3. **Project# 1010484**  
 15DRB-70204 MAJOR - SITE DEVELOPMENT PLAN FOR BUILDING PERMIT

RBA ARCHITECTS agent(s) for DREAM STYLE request the referenced/ above action for Lot 9A1B, **RENAISSANCE CENTER** zoned SU-1/ IP USES, located on the north side of N RENAISSANCE BLVD NE between CULTURE DR NE and CHAPPELL DR NE containing approximately 3.748 acres. (F-16) *[Deferred from 6/17/15]* **THE SITE DEVELOPMENT PLAN FOR BUILDING PERMIT WAS APPROVED WITH FINAL SIGN-OFF DELEGATED TO PLANNING FOR PARKS AND PLANNING COMMENTS.**

PROJECT: Renaissance Center / Tract 9A Warehouse/offices

SUBJECT: Site Plan for Building Permit

LANDSCAPE PLAN

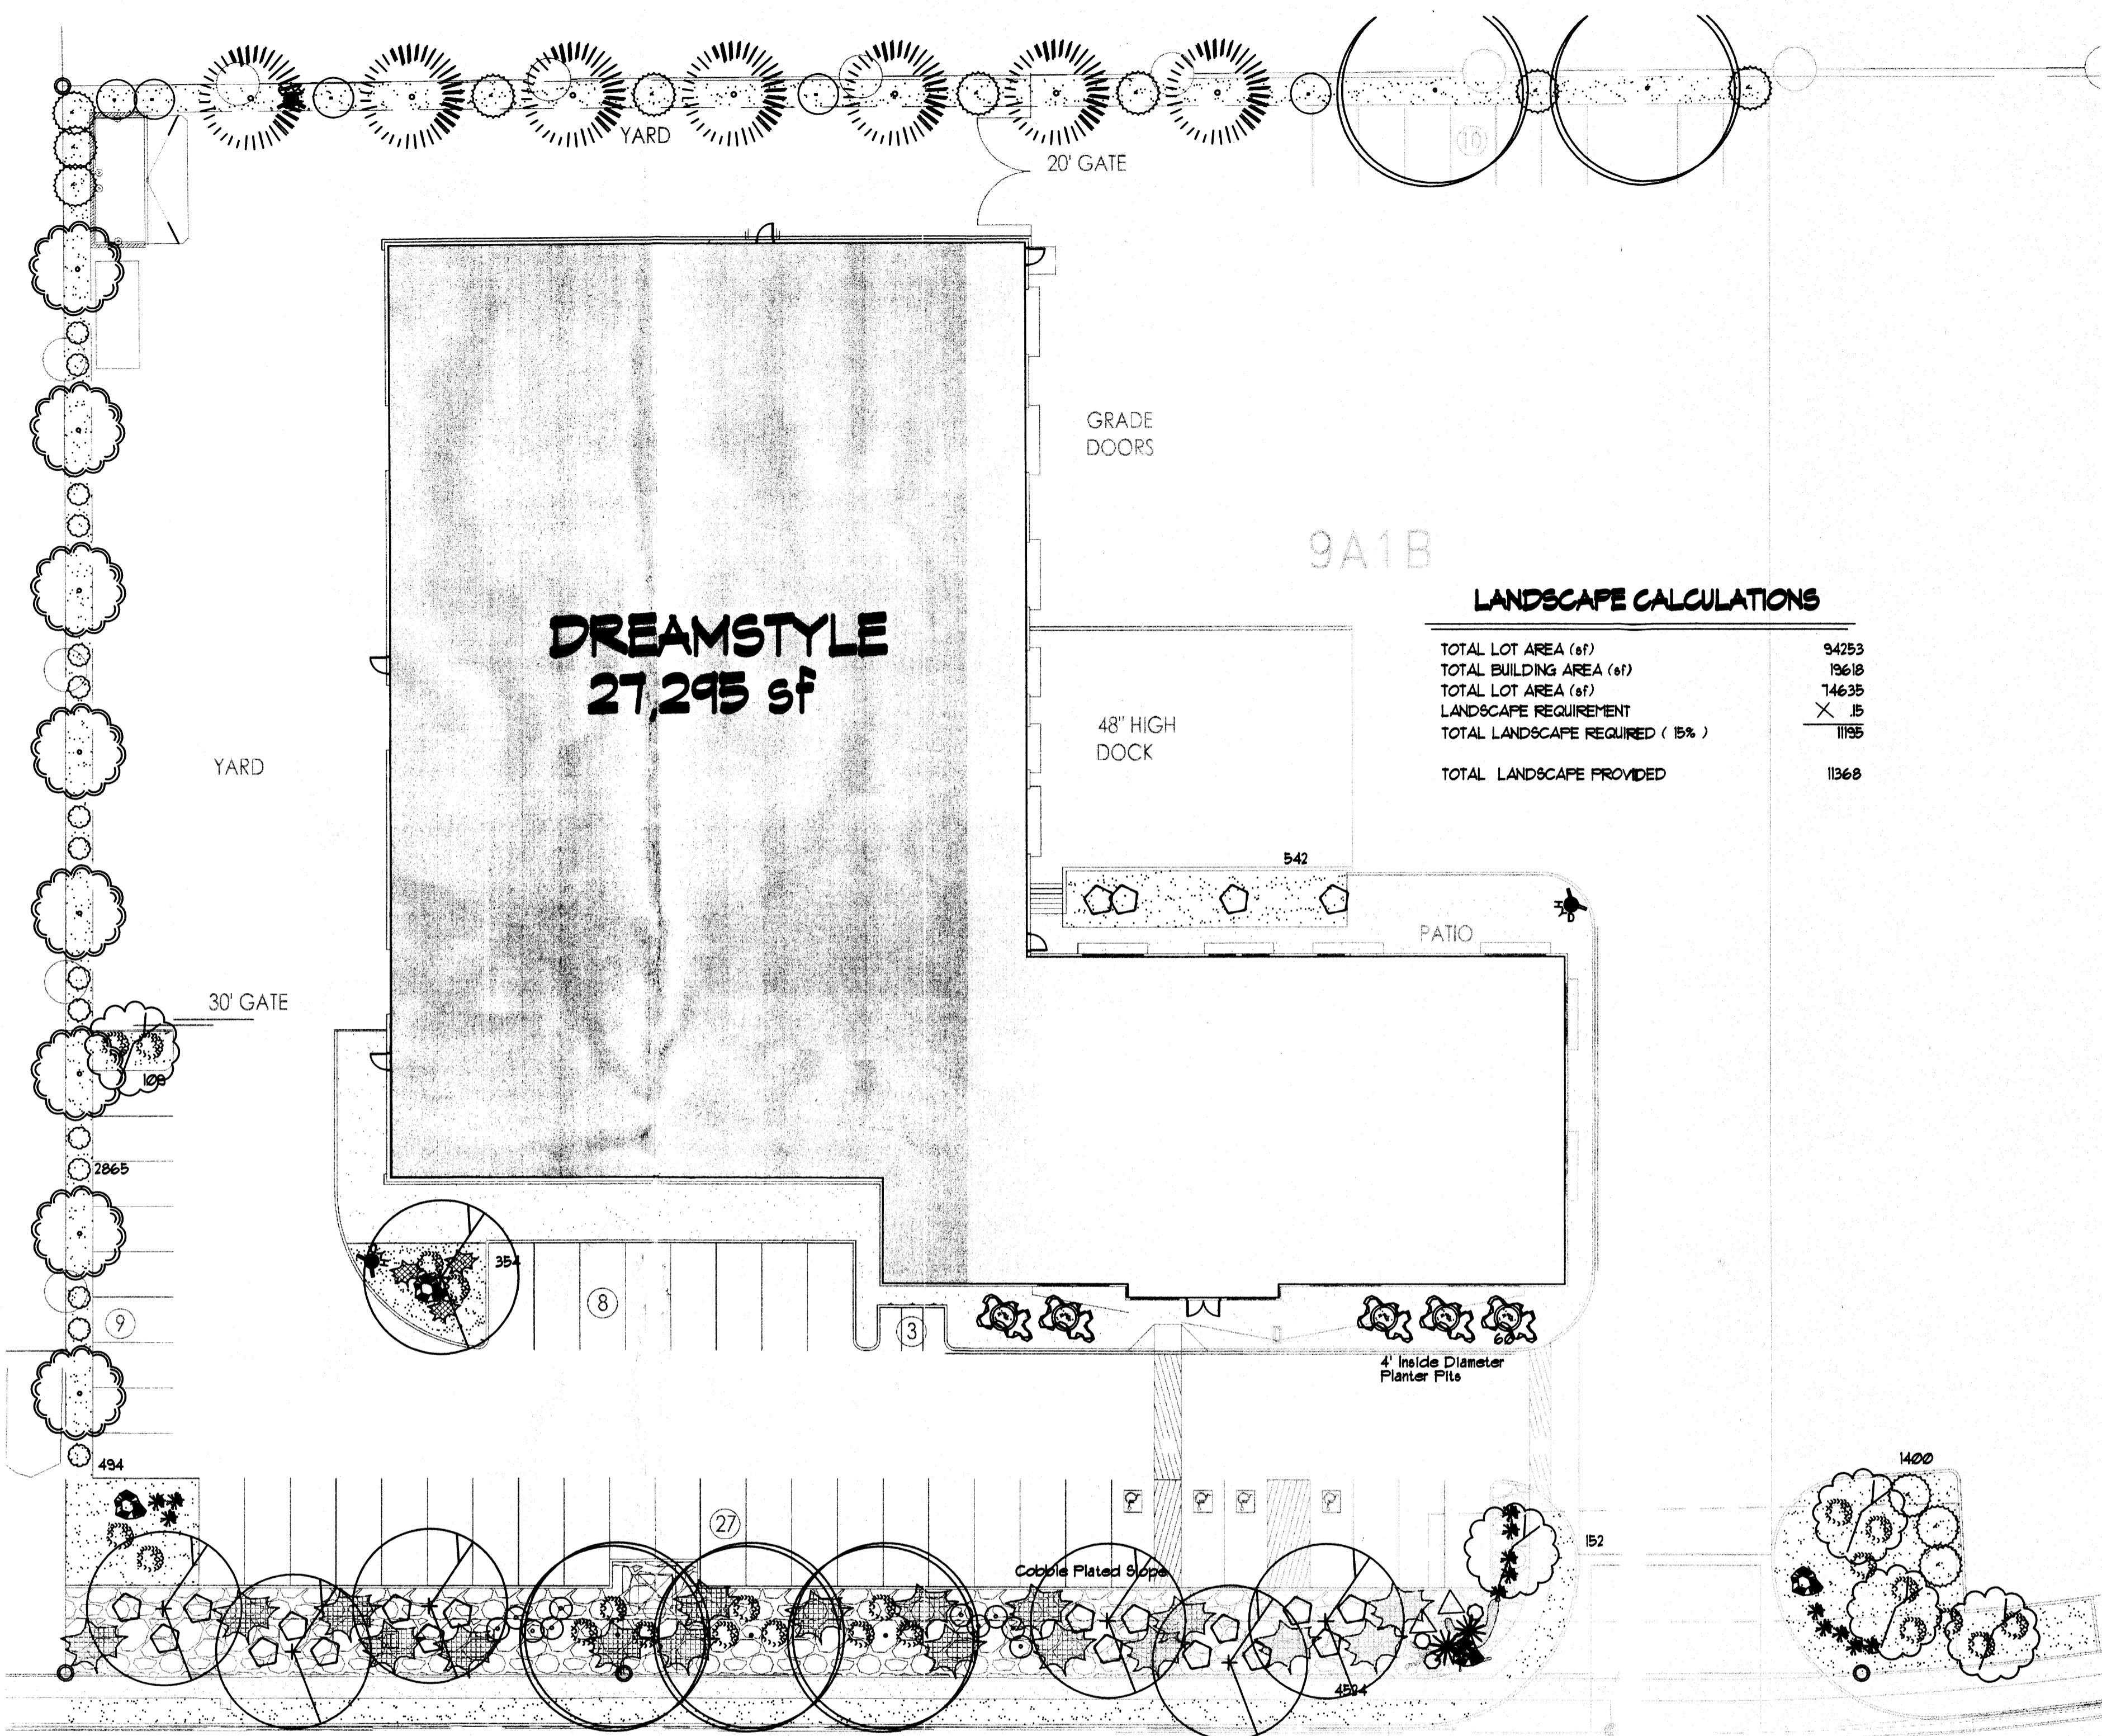
Planning: address parks & planning comments,  
15 day appeal period  
Landscaping Maintenance Adj property owner  
Responsibility Note
